COUNTY OF HARNETT LAND USE APPLICATION

Scott F. Cole
North Carolina Licensed Soil Scientist
312 Copples Road Ext.
Asheboro, NC 27205-0711
336.460.4554

Re: Site evaluation of existing conditions of Boone Trail Emergency Services; 7016 US 421 N, Lillington, NC, Harnett County, NC.

PERMIT # 28702

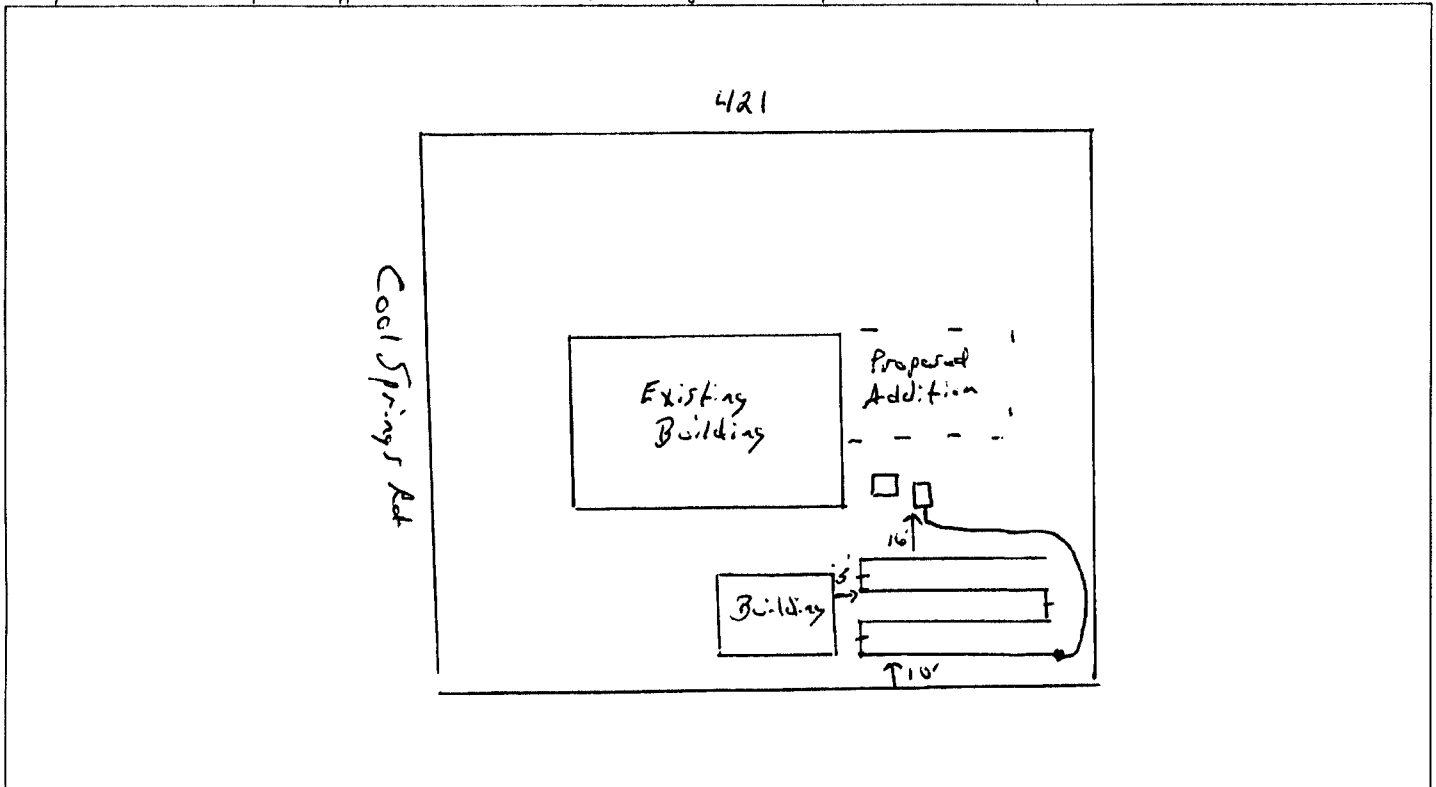
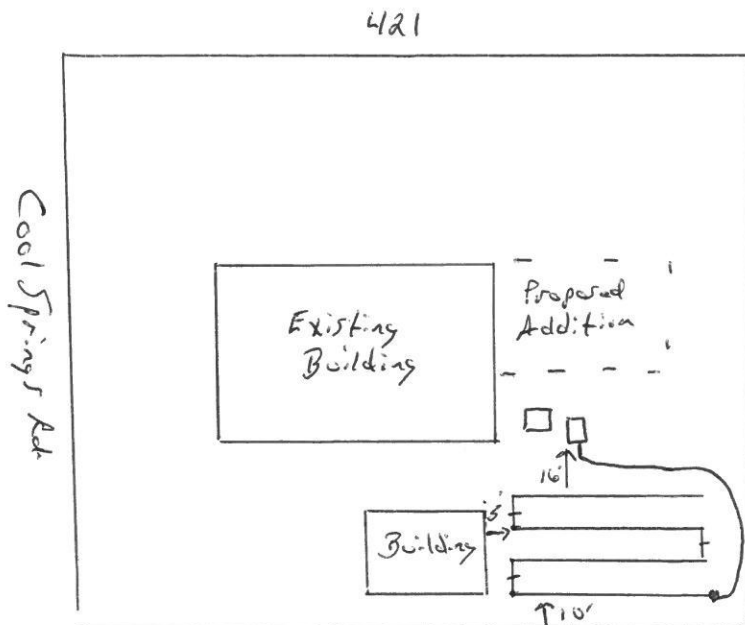
- **Property boundary markings show that portions of the nitrification trench are either within ten (10) feet of the property line or off the property altogether. The required minimum property line separation is ten (10) feet (*15A NCAC 18A .1950 (a)12 Location of Sanitary Sewage Systems*).**

- o Per *15A NCAC 18A .1938 (j)*, "the entire wastewater sewage system shall be on property owned or controlled by the person owning or controlling the system. Necessary easements, right of ways, or encroachment agreements, as applicable, shall be obtained prior to the issuance of a Construction Authorization for the system installation or repair".

Please note that building foundations are to be separated a minimum of five (5) feet from any portion of the septic system, which includes the septic tank, pump tank, supply/pump line and nitrification drain line. The proposed office addition was not staked at the time of the site inspection. It is strongly recommended to ensure that the minimum setback requirements are met prior to the beginning of this project.
